PROJECT MEMO

RE: Project # SP-2025-00053_Savio Ridge Site Plan-EPC Major Amendment

DATE: 07/18/2025

- C. This is a request for: a major amendment to a Site Plan EPC for one additional single-family detached lot in the southeast corner of the subdivision. The amendment will increase the subdivision total lots from 212 to 213. A Site Plan-EPC review is required pursuant to IDO section 14-16-2-6(B)(7).

SAVIO RIDGE

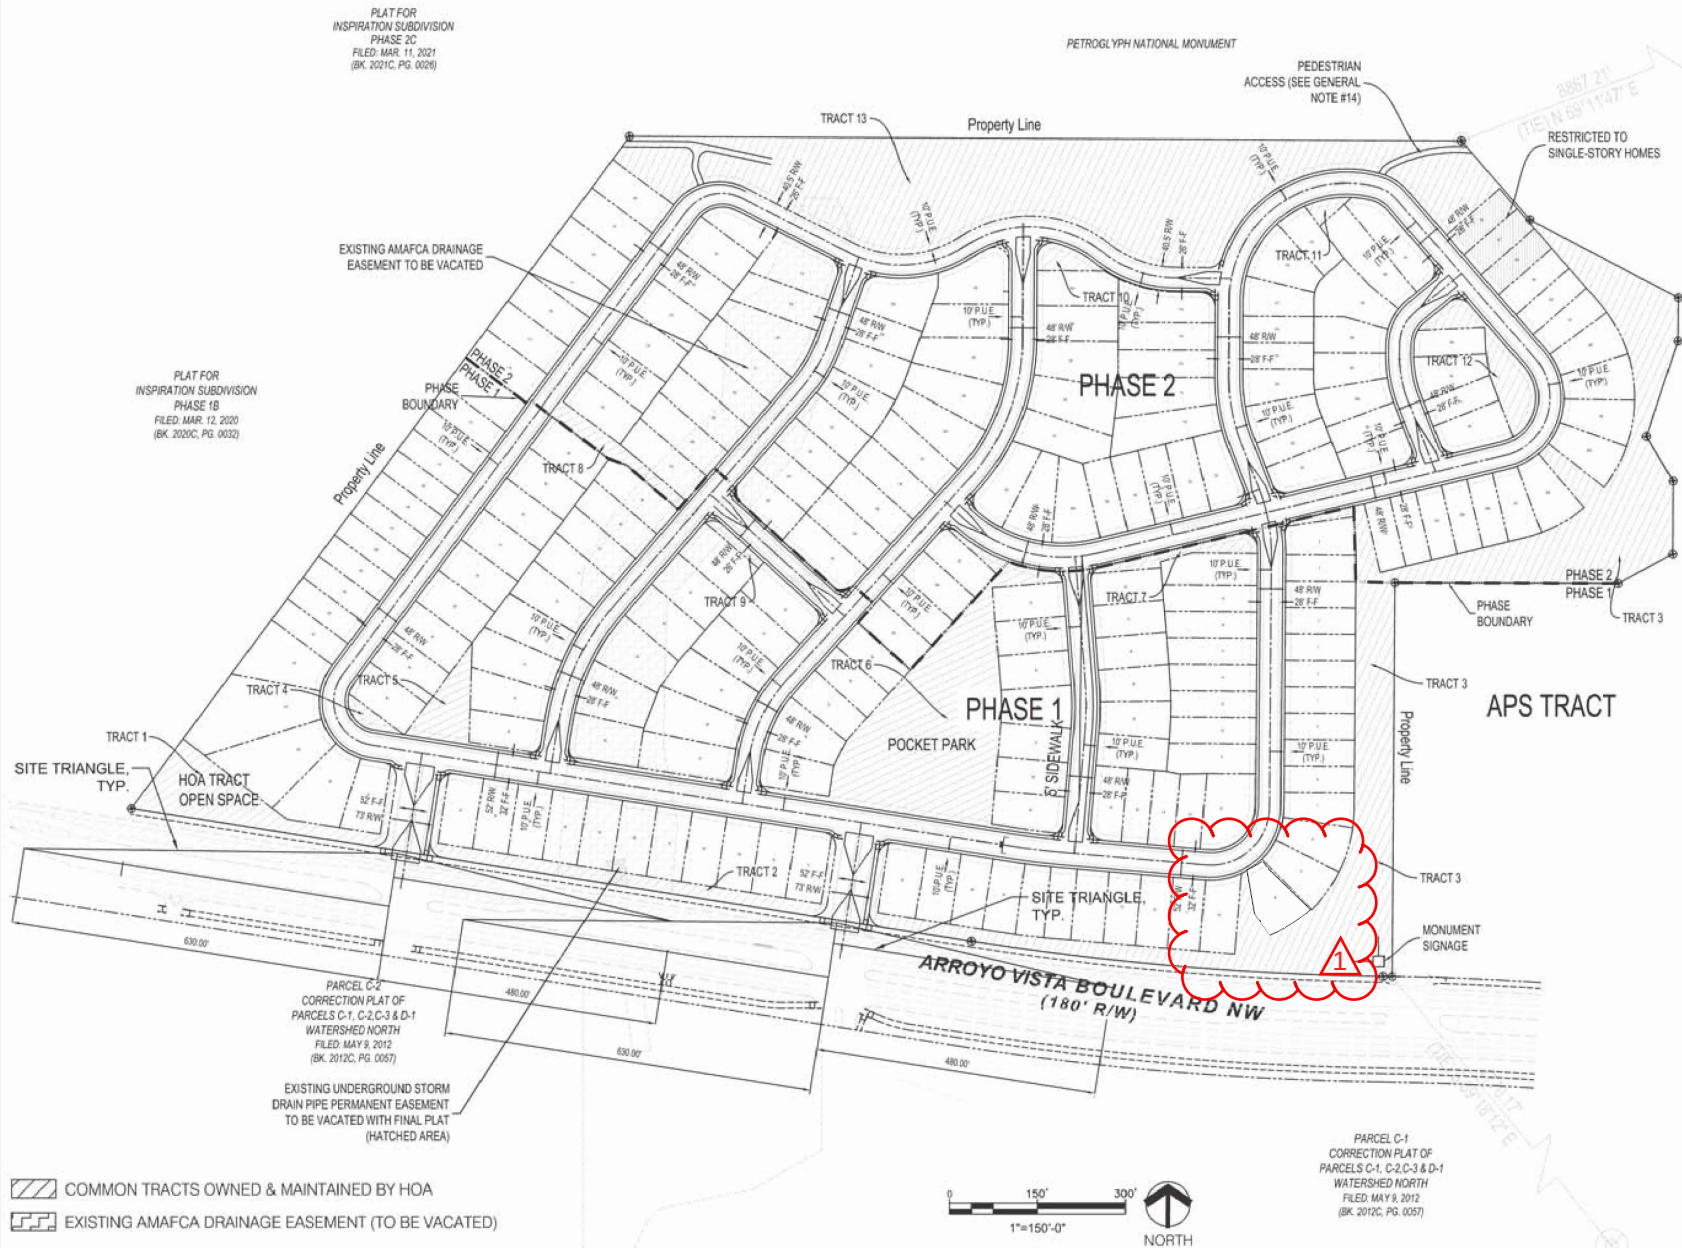
- A. Update site vicinity map to show the new bulk plat line.
- B. Site plan Sheet 1 of 28 has the proposed lot and revision cloud on it.
- C. The Grading Plan sheet 10 of 28 were approved by hydrology on 5-2-25 with the proposed additional lot showing.
- D. Overall Grading Plan sheet 4 of 28 has a hydrology approved stamp but it is not signed.
- E. The Conceptual Utility Plan shows the proposed single lot. Is this drawing still a “Concept?” If not, please remove.
- F. The Planting Plans LP-1.0 Sheet 15 of 25 and LP-1.3 18 of 28 have a cloud surrounding the new lot with updated landscaping. Needs revision delta and note if the cloud is to remain.
